**From:** Simon Davis  
**Sent:** 29 March 2019 11:47  
**To:** [REDACTED]  
**Subject:** RE: BR/326/18/PL

**The royal Hotel - BR/326/18/PL**

**Description of proposal**

The application is for the refurbishment of the existing building, external alterations, extensions and reconfiguration of a previously permitted conversion. The proposal is to provide an A3 restaurant and 27 flats.

TYPICAL WINDOW DETAIL

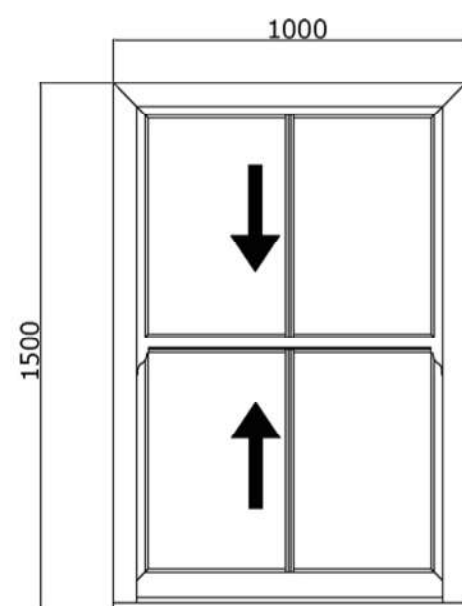
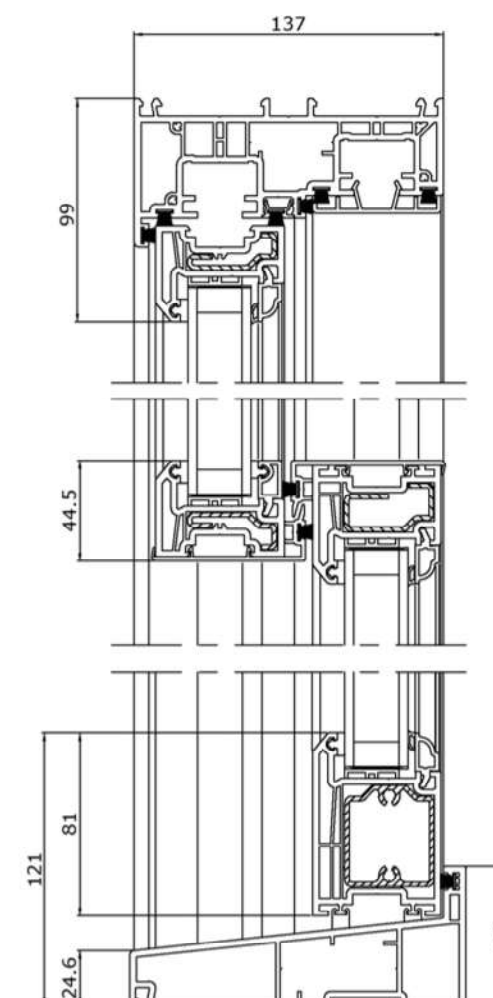
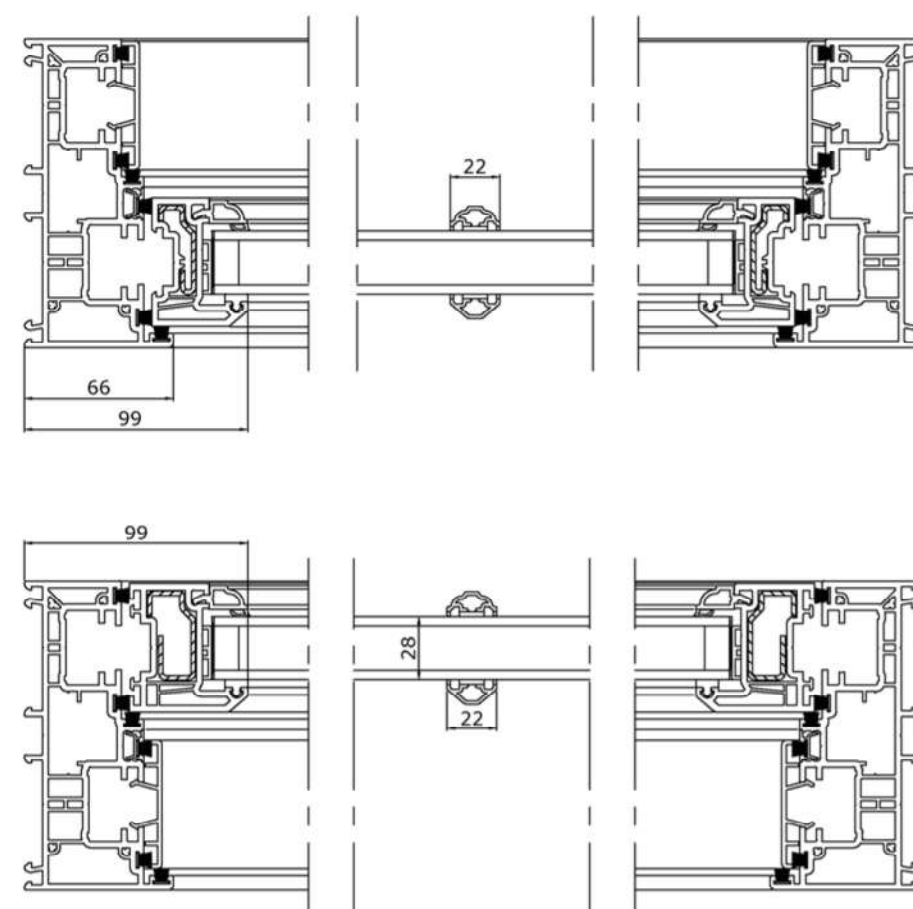
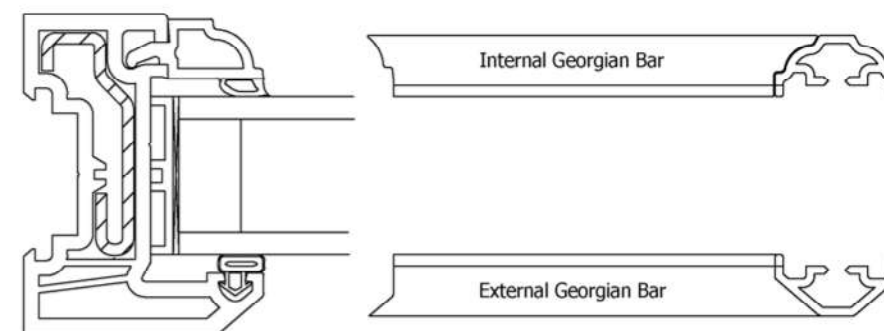
- Can you confirm that the sash windows will be fully sliding. It is not clear from the drawing.
- Would prefer to not have stick on glazing bars but this can be accepted and the window details are otherwise good.
